Markup Summary

dsdparsons (3)

# Preliminary Plan for ABERT RANCH SUBDIVISION

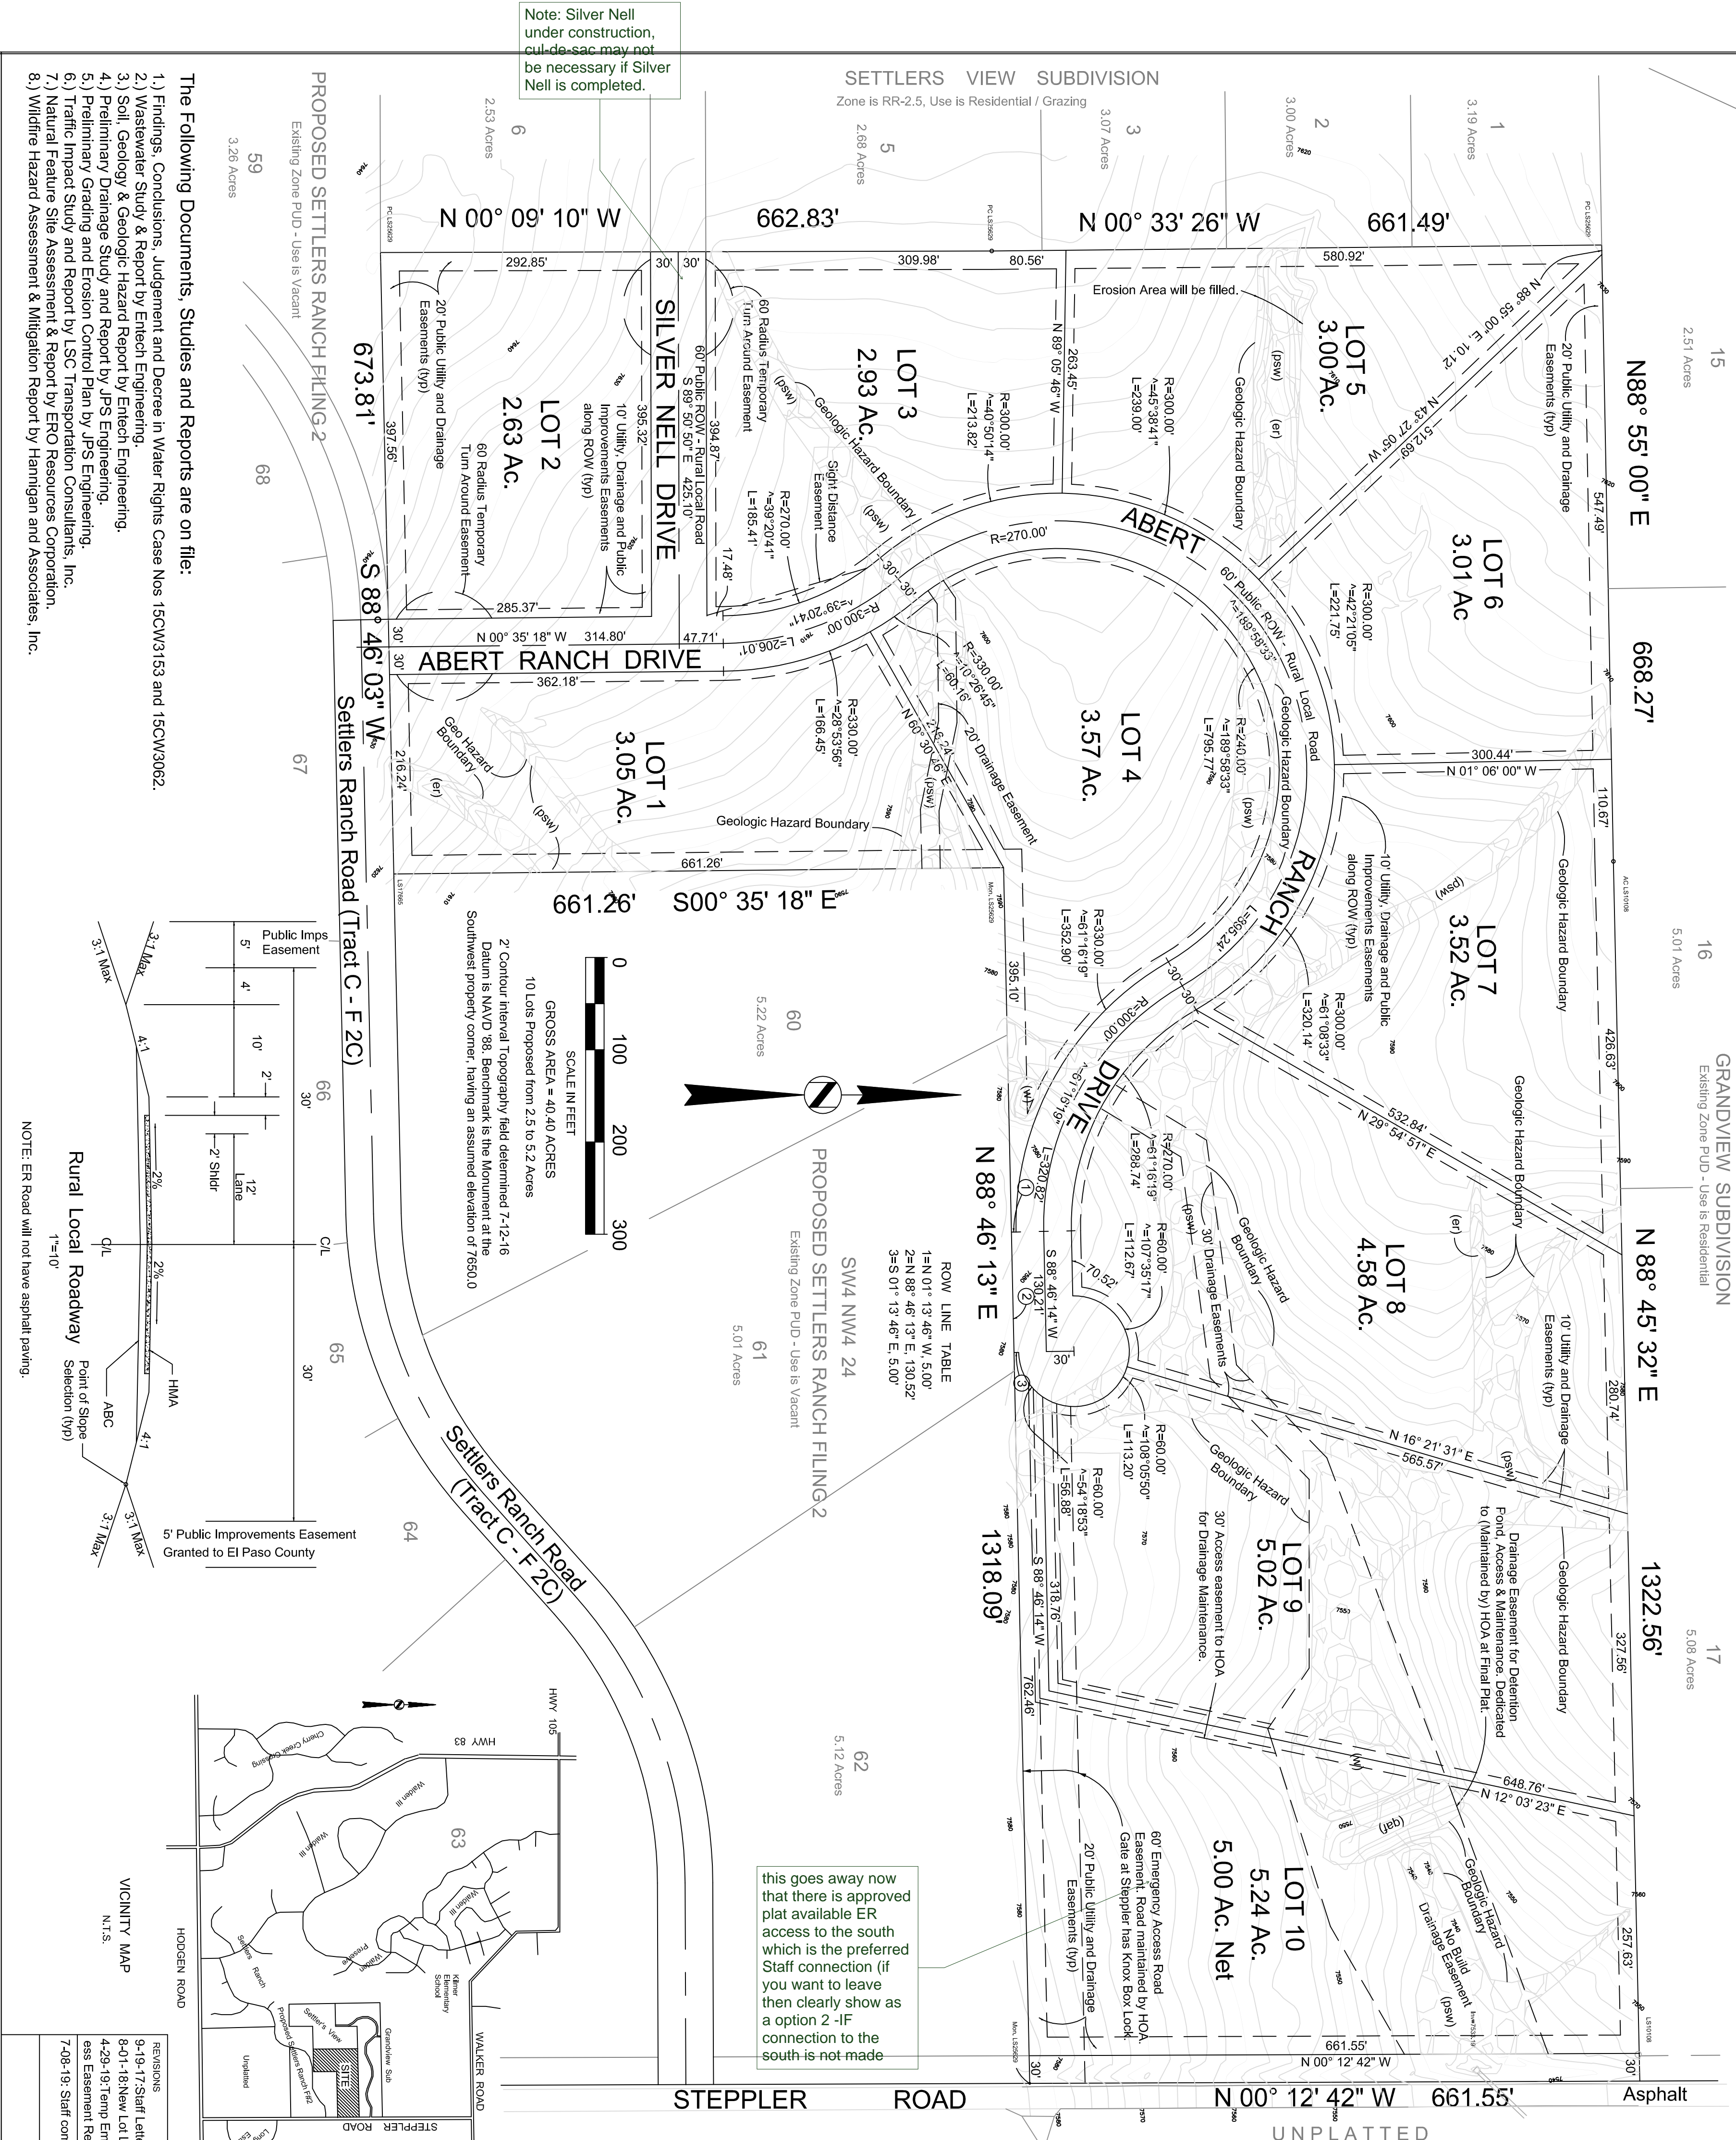
grey the topo and the geo constraints

provide detail for ER road

label the constraint hatch-it is not easily read & add legend
